Engineers Comments Regarding Surface Water Drainage

APPLICATION NO: BN/75/19/PL

Site Address: Land adjacent to Cherry Trees Lake Lane Barnham PO22 0AD

Description of Works: 1 No. dwelling & associated works.

APPENDIX B - DRAINAGE STRATEGY

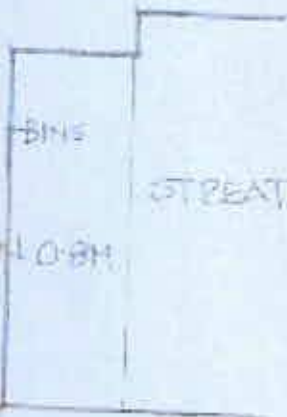
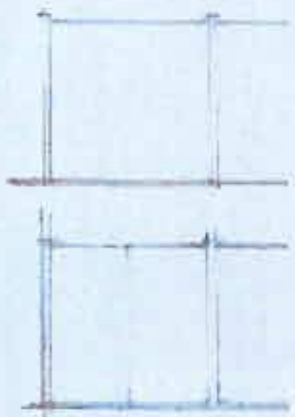
A flood risk assessment has been supplied as part of this application. This states that infiltration will not be viable due to the likely presence of clay. This is insufficient justification, on site infiltration and groundwater monitoring must be completed to establish if infiltration is feasible. The surface water drainage strategy also states that flow would be restricted to 1l/s and discharged to surface water sewer. It should be noted that our minimum acceptable discharge is 2l/s due to the risk of blockage with smaller flows. The drainage which the FRA assumes to be a surface water sewer is actually highways drainage, it is not acceptable to discharge into a highways drainage system.

If you are minded to approve this application please apply the following condition to ensure that the development is adequately drained and does not increase flood risk elsewhere:

"Development shall not commence, other than works of site survey and investigation, until full details of the proposed surface water drainage scheme have been submitted to and approved in writing by the Local Planning Authority. The design should follow the hierarchy of preference for different types of surface water drainage disposal systems as set out in Approved Document H of the Building Regulations, and the recommendations of the SuDS Manual produced by CIRIA. Winter groundwater monitoring to establish highest annual ground water levels and winter Percolation testing to BRE 365, or similar approved, will be required to support the design of any Infiltration drainage. No building / No part of the extended building shall be occupied until the complete surface water drainage system serving the property has been implemented in accordance with the agreed details and the details so agreed shall be maintained in good working order in perpetuity."

"Infiltration rates for soakage structures are to be based on percolation tests undertaken in the winter period and at the location and depth of the proposed structures. The percolation tests must be carried out in accordance with BRE365, CIRIA R156 or a similar approved method and cater for the 1 in 10 year storm between the invert of the entry pipe to the soakaway, and the base of the structure. It must also have provision to ensure that there is capacity in the system to contain below ground level the 1 in 100 year event plus 40% on stored volumes, as an allowance for climate change. Adequate freeboard must be provided between the base of the soakaway structure and the highest recorded annual groundwater level identified in that location. Any SuDS or soakaway design must include adequate

groundwater monitoring data to determine the highest winter groundwater table in support of the design. The applicant is advised to discuss the extent of groundwater monitoring with the Council's Engineers. Supplementary guidance notes regarding surface water drainage are located here <https://www.arun.gov.uk/surfacewater> on Arun District Councils website. A surface water drainage checklist is available here <https://www.arun.gov.uk/drainagechecklist> on Arun District Councils website, this should be submitted with a Discharge of Conditions Application."
